15 – 17 Uxbridge Road, Hayes: Application for Temporary Planning Permission - Transport Note – Response to Highways Comments

Ref: JN/ITL19655-002a

Date: 10 July 2024

Date:	Jul-24	Scale:	1:500 @ A3	Checked by:	BM	Drawn by:	EL
Project:	15-17 UXBRIDGE ROAD, HAYES UB4 0JN						
Drawing title:	Proposed Ground Floor						
Reference:	URM	Draw No:	200	Rev:	B

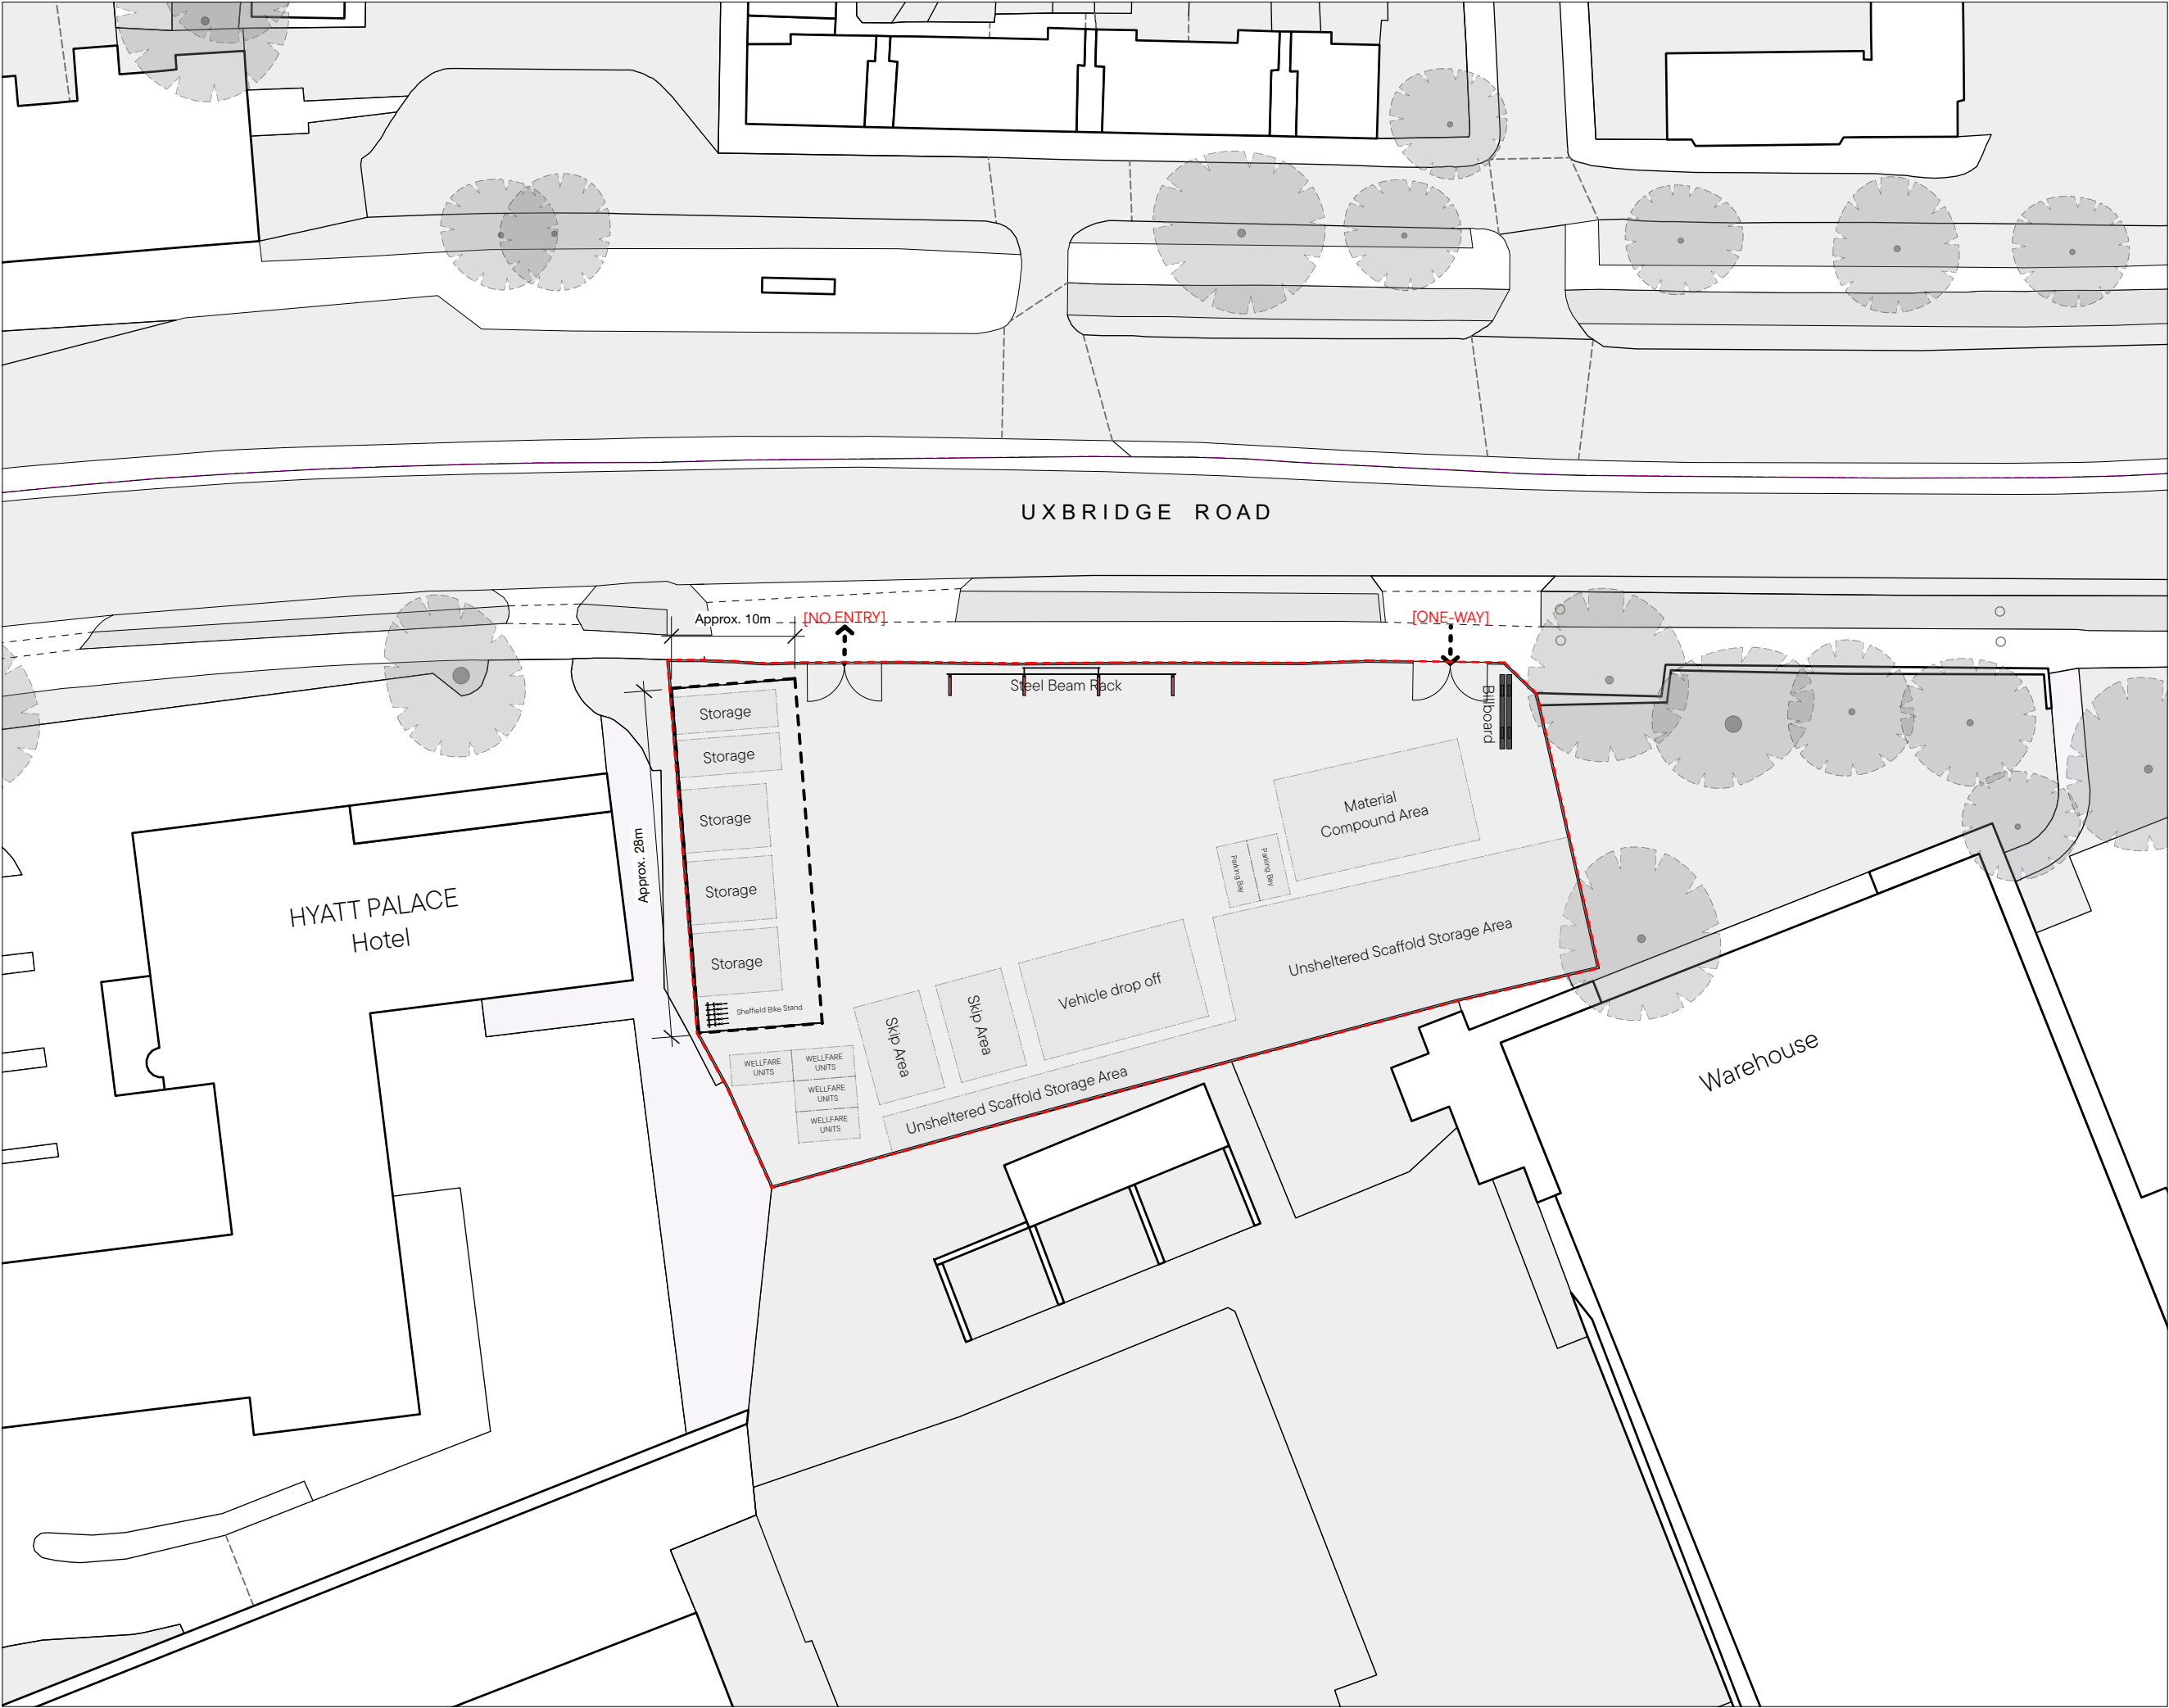
"Vehicular access to the site would be gained from 2no. existing vehicle crossovers. Drawing URM 200 titled Proposed Ground Floor shows the access points which are gated, this would not be acceptable as vehicles wanting to enter the site would be required to wait on A4020 Uxbridge Road whilst gates are being opened, causing obstruction and affecting the free flow of traffic to the detriment of highway safety."

Concerns would also be raised regarding the use of the 2no. existing vehicle crossovers which are shown within the Transport Note Ref VP/JN/AT/ITL16339-001a Appendix A Traffic Survey Results as 'Entrance -1 Entry/Exit' and 'Entrance -2 Entry/Exit'. Having each access serving both as an 'Entry/Exit' would cause conflict and confusion leading to vehicles waiting on A4020 while opposing vehicles leave, this would be to the detriment of highway safety which not be acceptable.

The applicant would therefore be required to relocate gates back from the adopted highway at A4020 Uxbridge Road with restrictions provided to ensure that vehicles may enter only through the southern crossover and exit only through the northern crossover with the means of restraint. The Highway Authority require that an amended layout shown on a revised drawing and is submitted for approval."

- 2.1.1 Site gates have been located at the site for a number of years. These are locked opened during the hours of operation of the site and each arriving/departing vehicle during the day does not need to wait on the highway for any gate operation; they can simply drive into and out of the site. If LBH consider it necessary, a suitably worded planning condition requiring gates to be locked open during the hours of operation could be applied to a permission.
- 2.1.2 In light of the observed operation of the site, the Applicant proposes a one-way operation at the site with one-way inbound and no-entry signage to be introduced on the site boundary.
